From: Cllr. Richard Bower
Sent: 10 May 2018 16:38
To: Juan Baeza
Subject: Re: 25 Sea Way, Middleton-on-Sea - Planning Application M/41/18/HH

Subject: 25 Sea Way, Middleton-on-Sea - Planning Application M/41/18/HH

PROPOSED ELEVATIONS

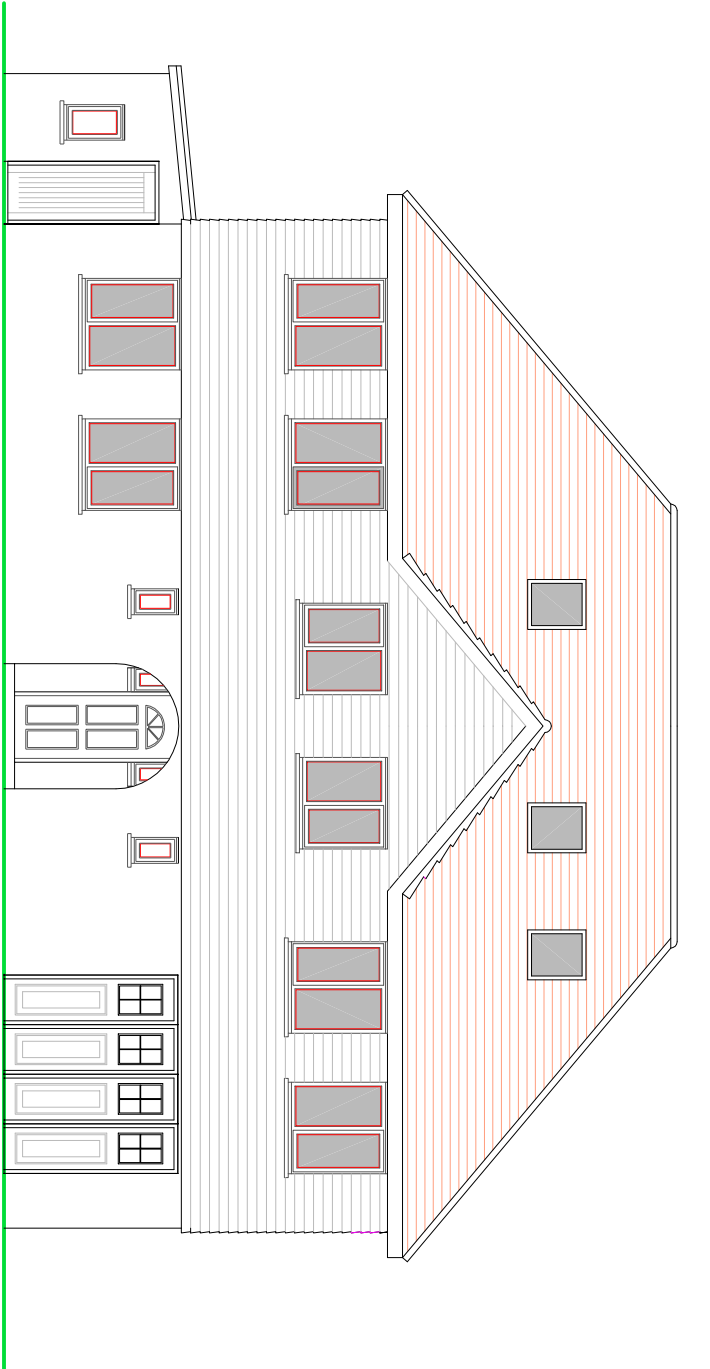
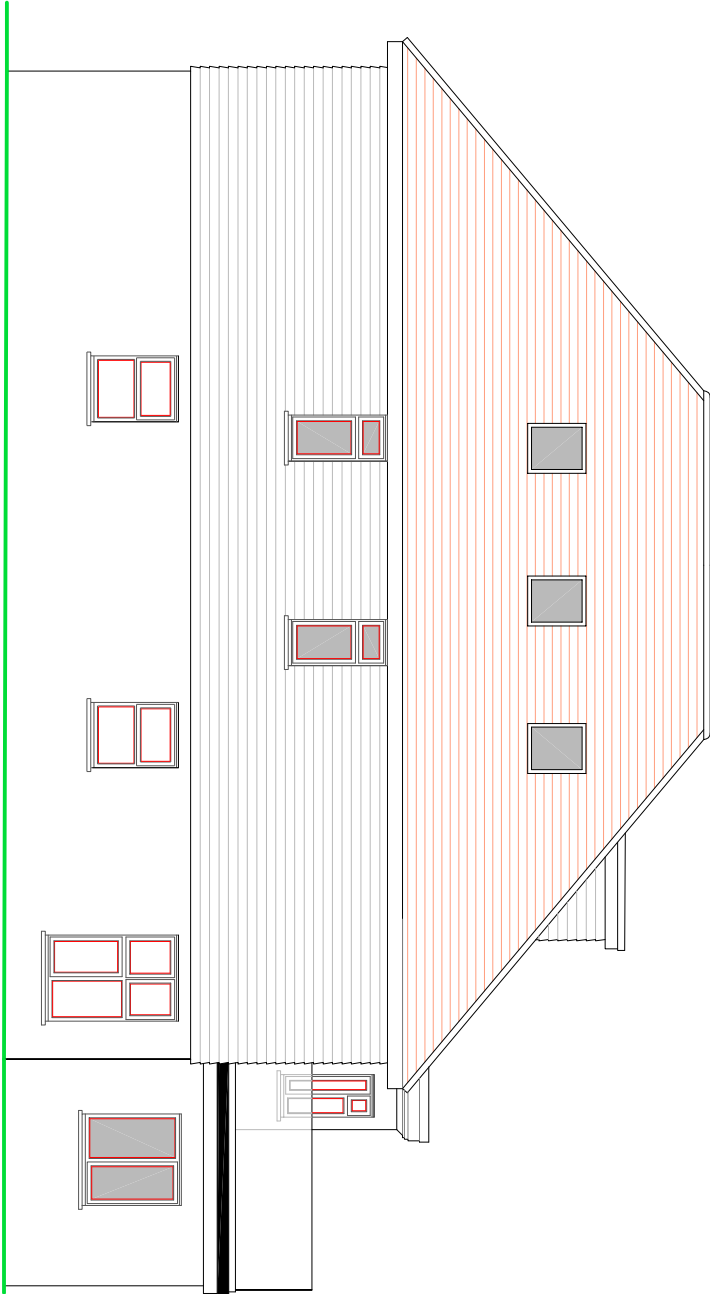
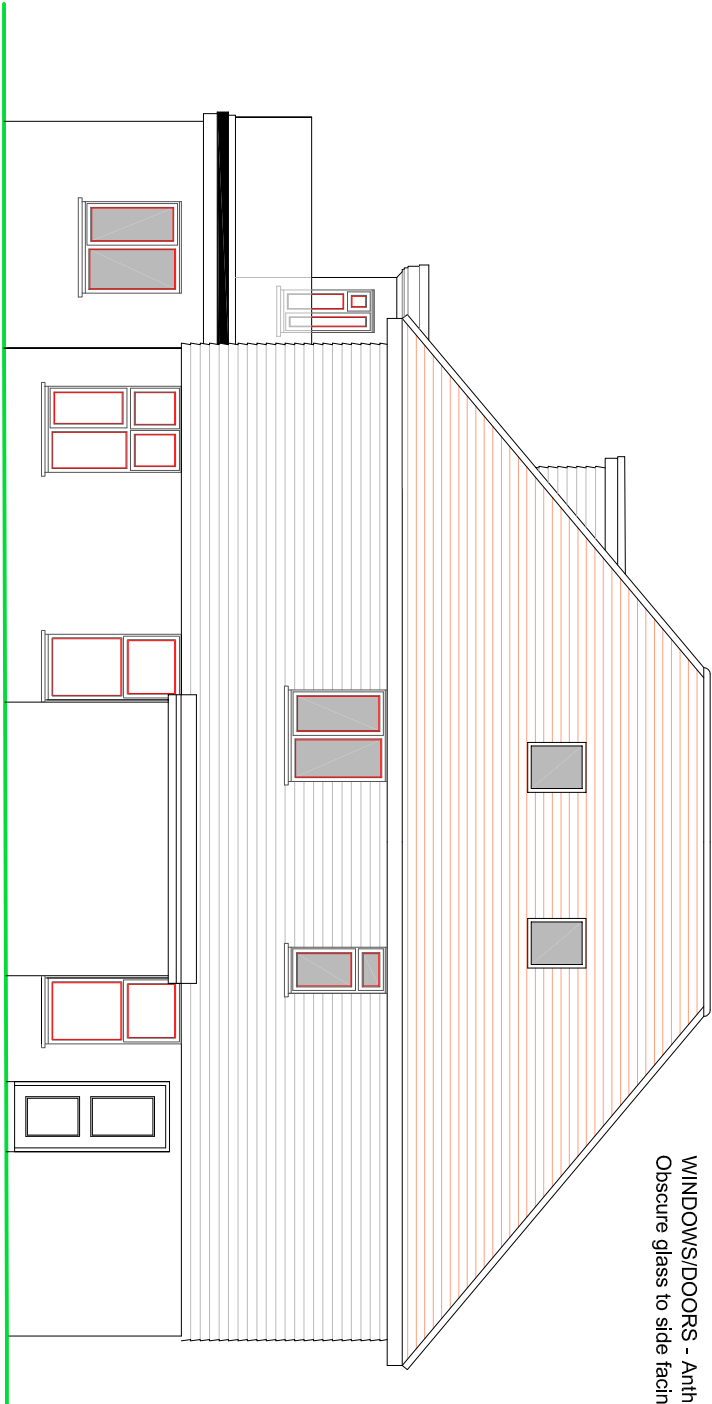
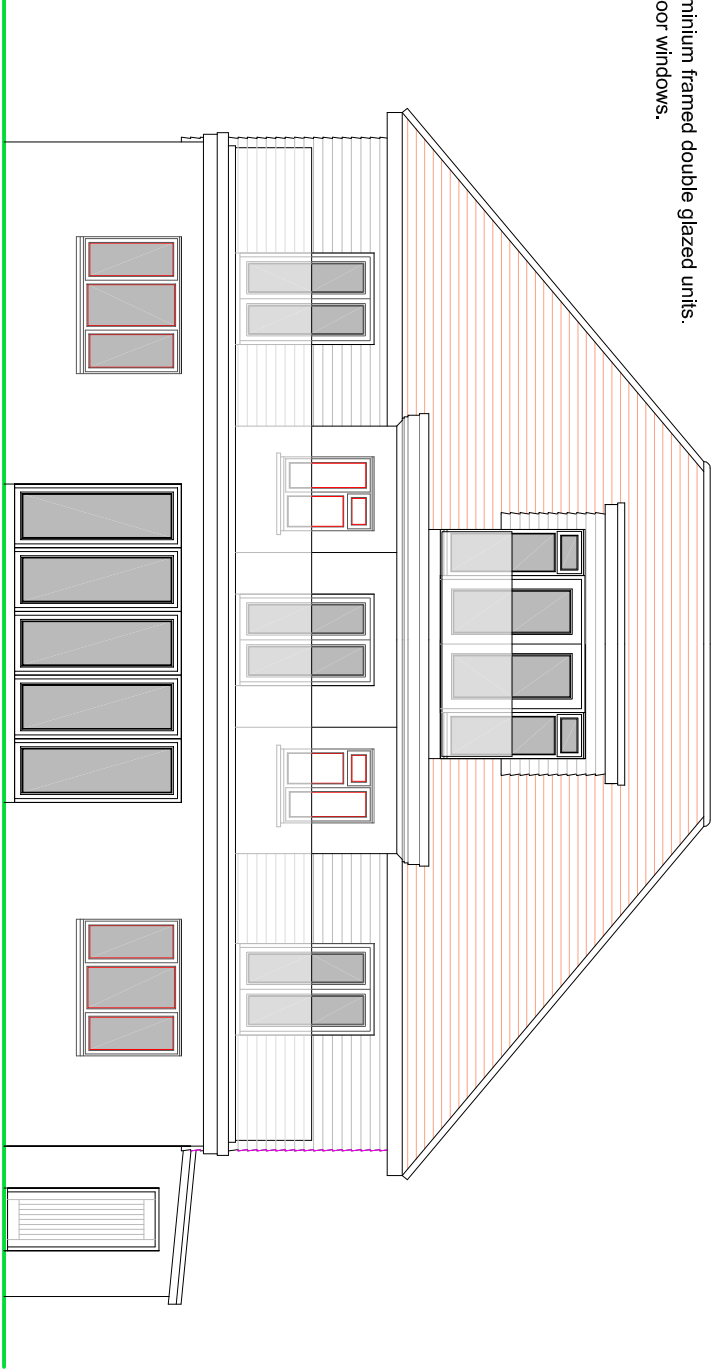
1. It's out of character with the street scene;
2. The building will be too high and out of keeping with neighbouring properties;
3. The proposals will, if implemented, adversely affect the Area of Special Character and
4. It will constitute over development.
